Job No. GE19/150  
Ref: 24822  
Author: Davor Dragun and Robert Maxwell

3<sup>rd</sup> December 2019

**RE: CLARIFICATION ON GENERAL DRAINAGE COMMENTS – TWEED VALLEY HOSPITAL  
– CUDGEN ROAD, KINGSCLIFF**

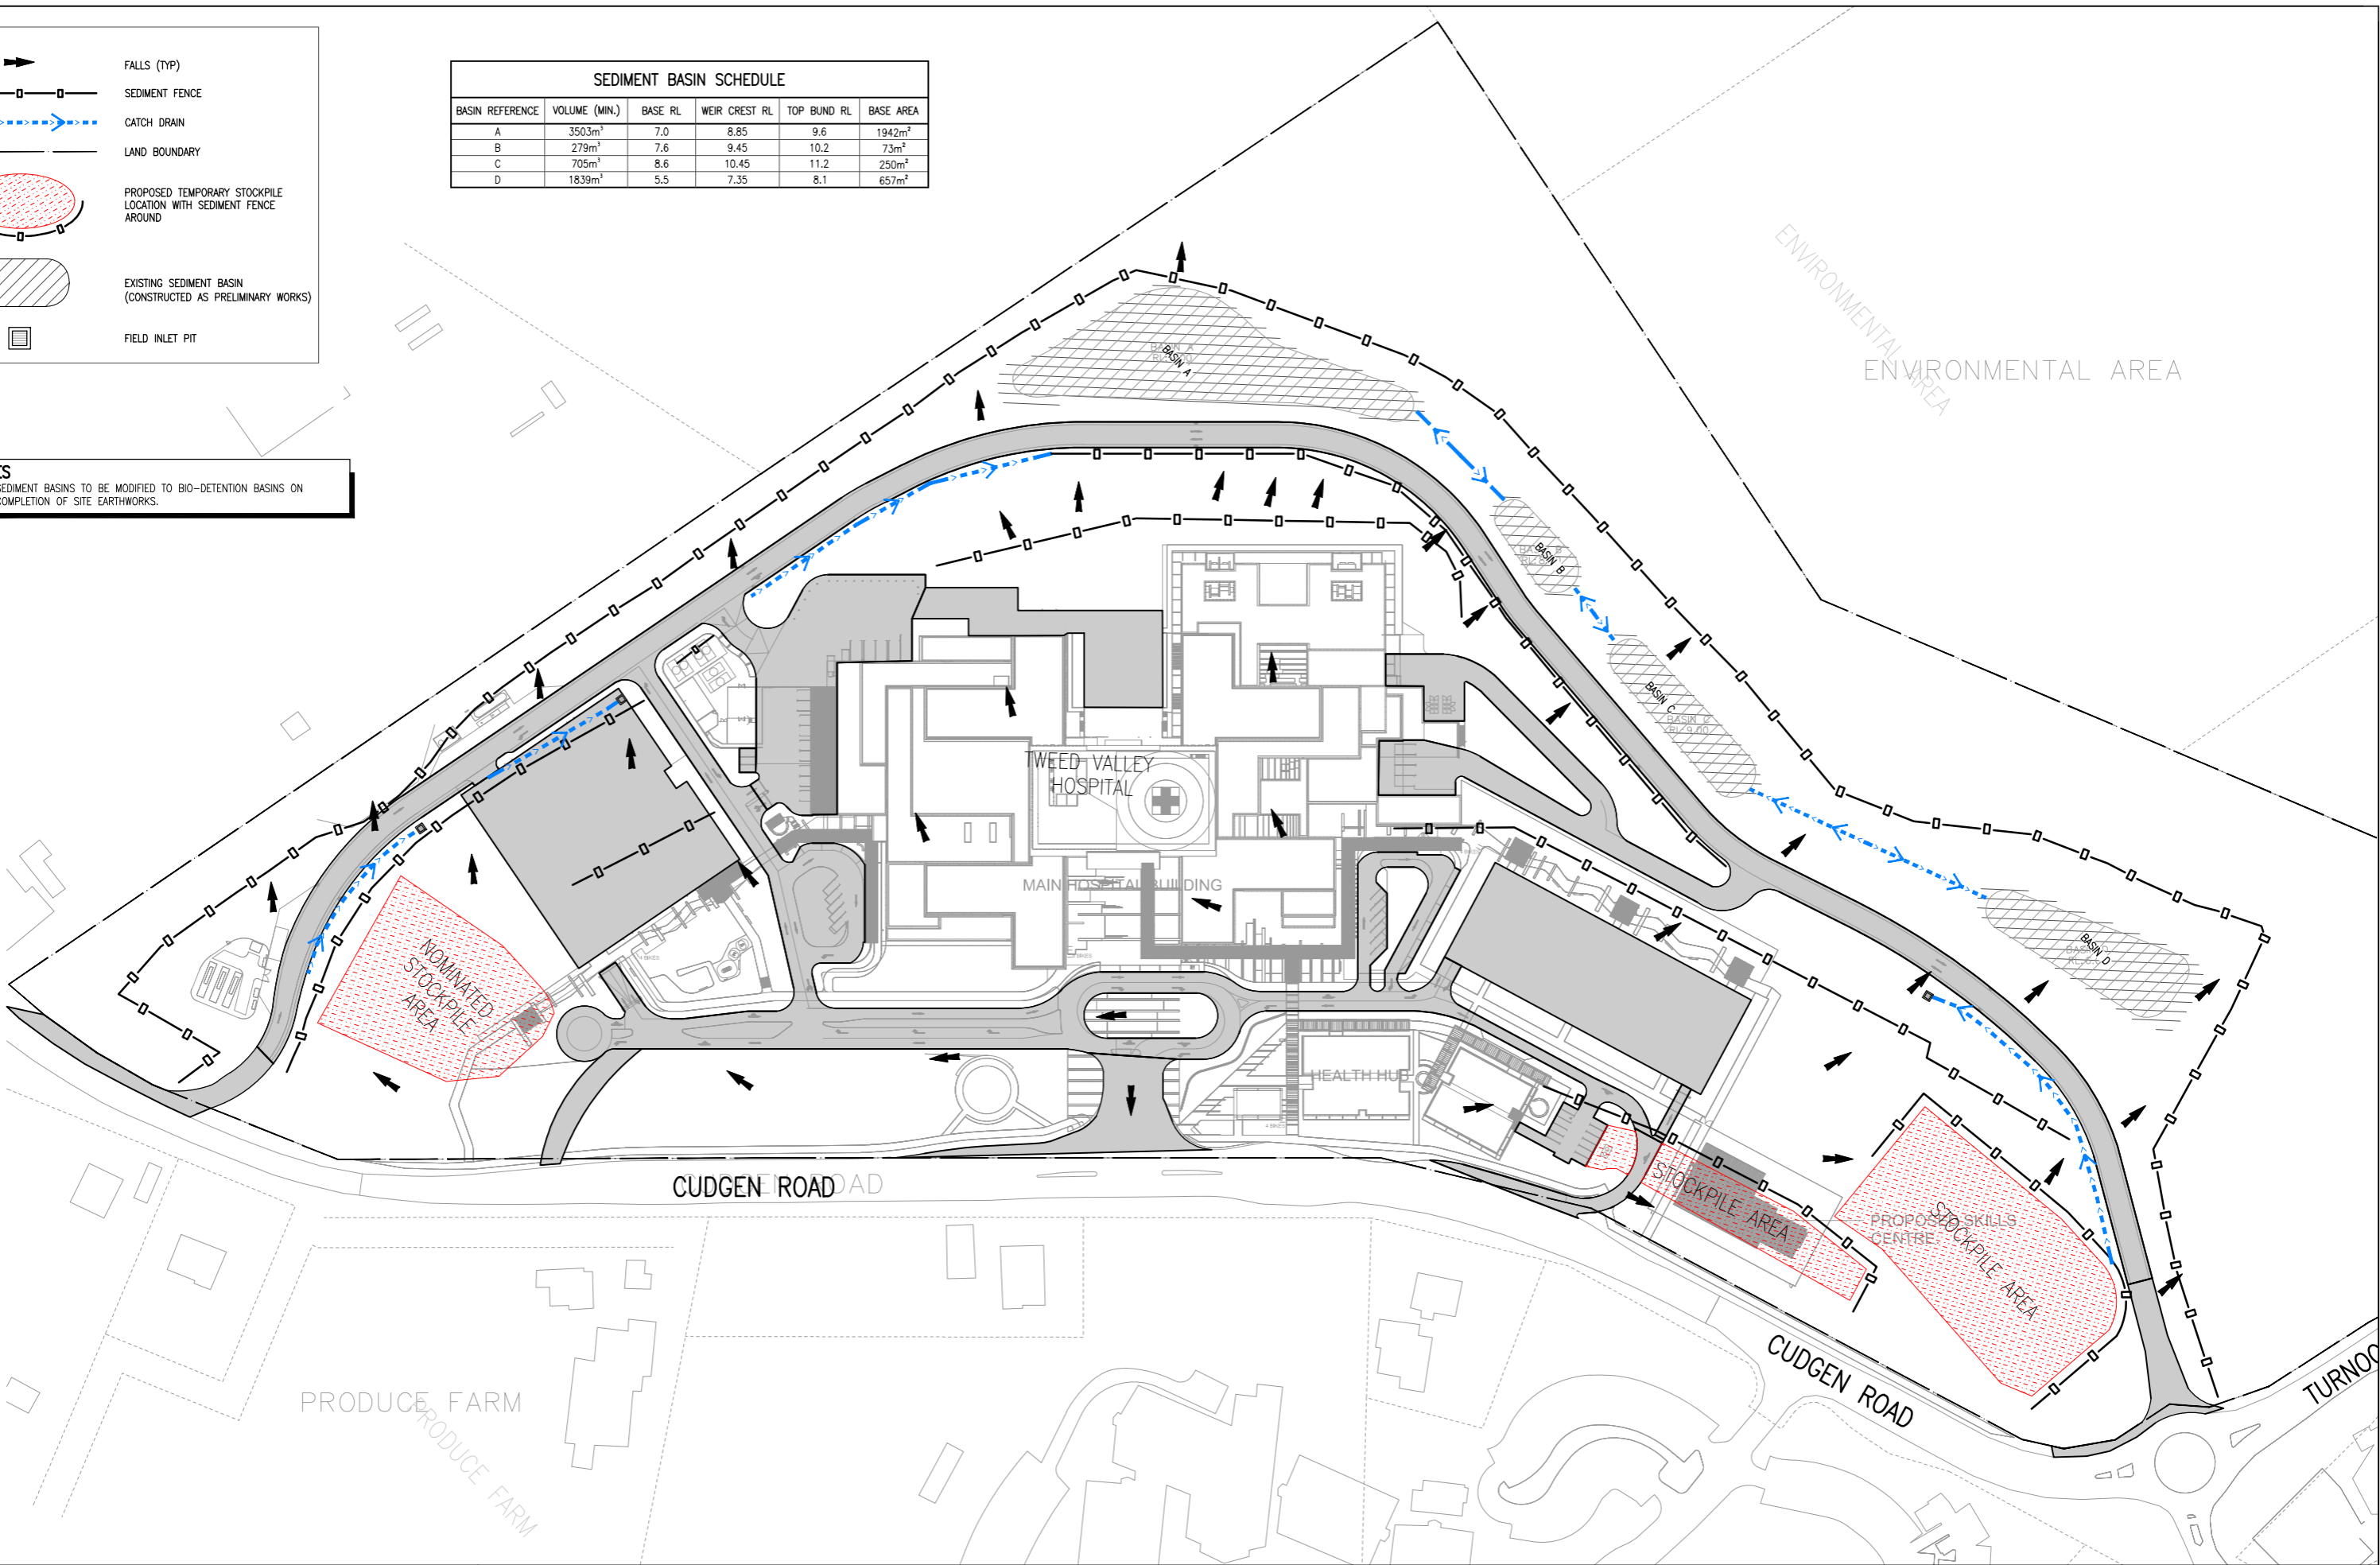
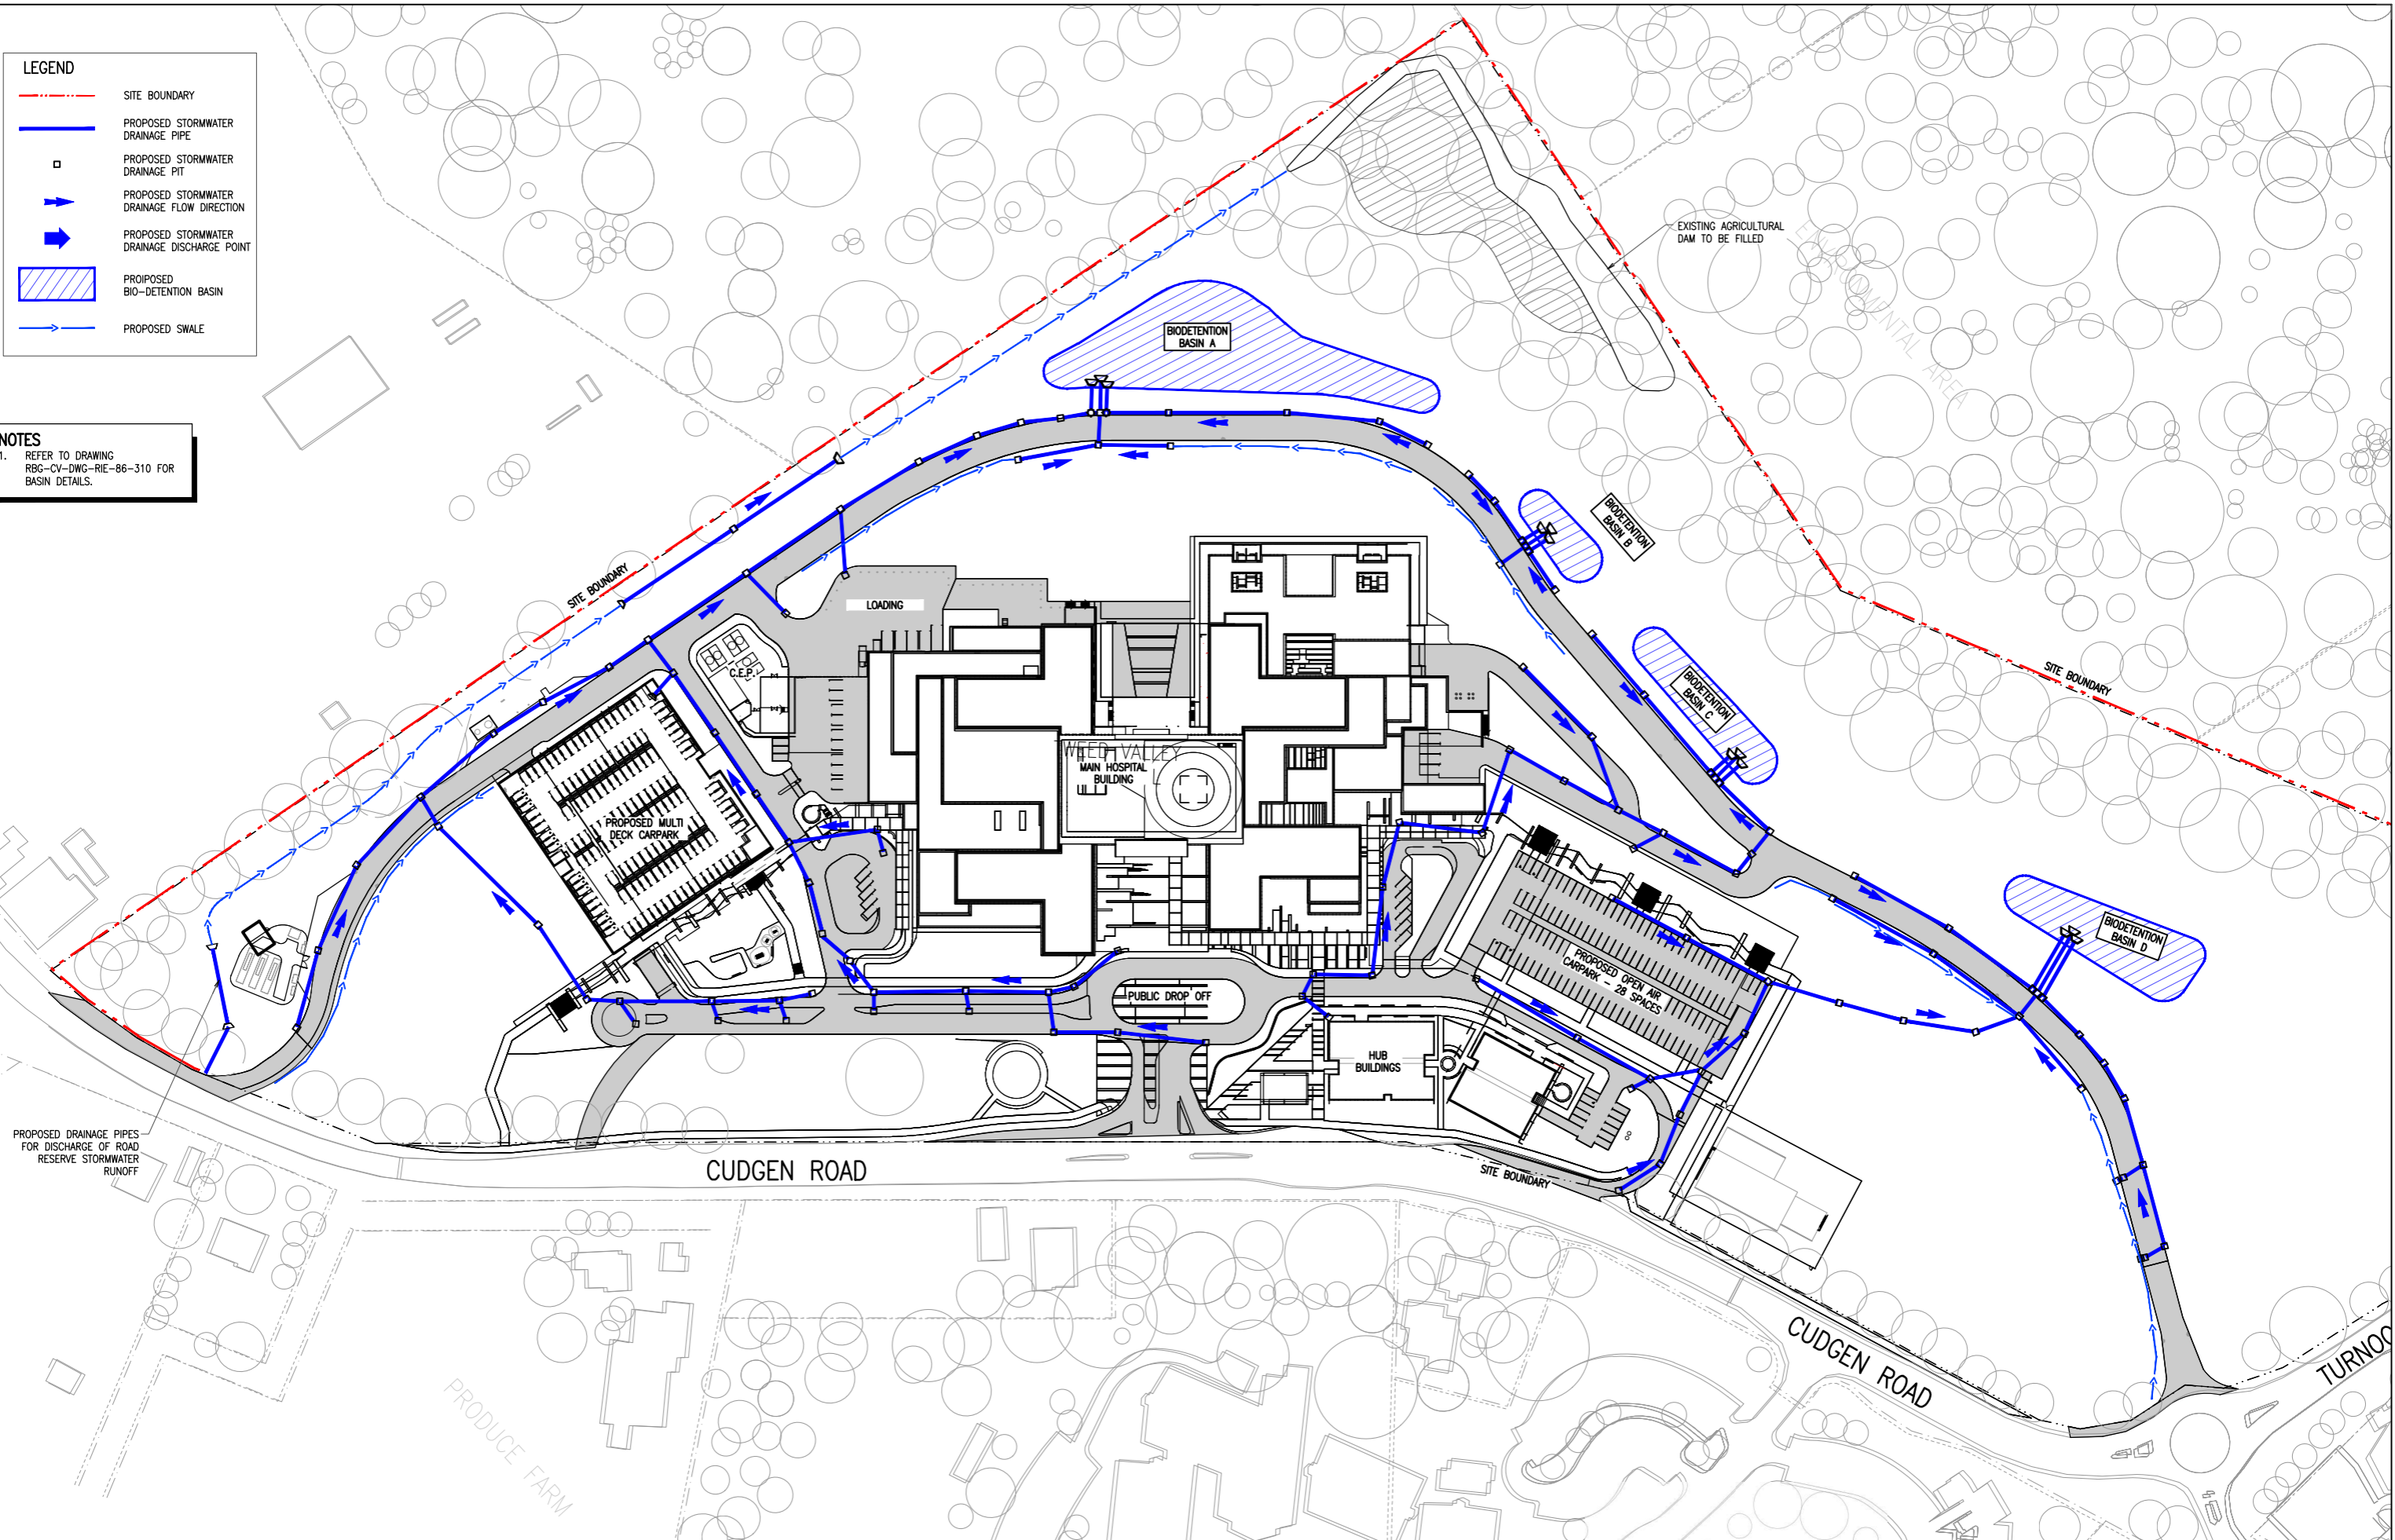
Upon review of the investigations carried out, the natural clay soils encountered on the site are permeable and susceptible to loss of strength at elevated moisture contents. If adopted, the infiltration trenches are expected to have affect onto the sloping grounds on the site resulting in possible instability associated with slips, creep or erosion. The same/similar would be expected if liners are removed from sediment basins.

In summary, all sloping grounds on the site should have suitable drainage system(s) installed to maintain long term stability and to prevent slips, creep or erosion. Discharging onto the sloping areas should not be permitted at any time.
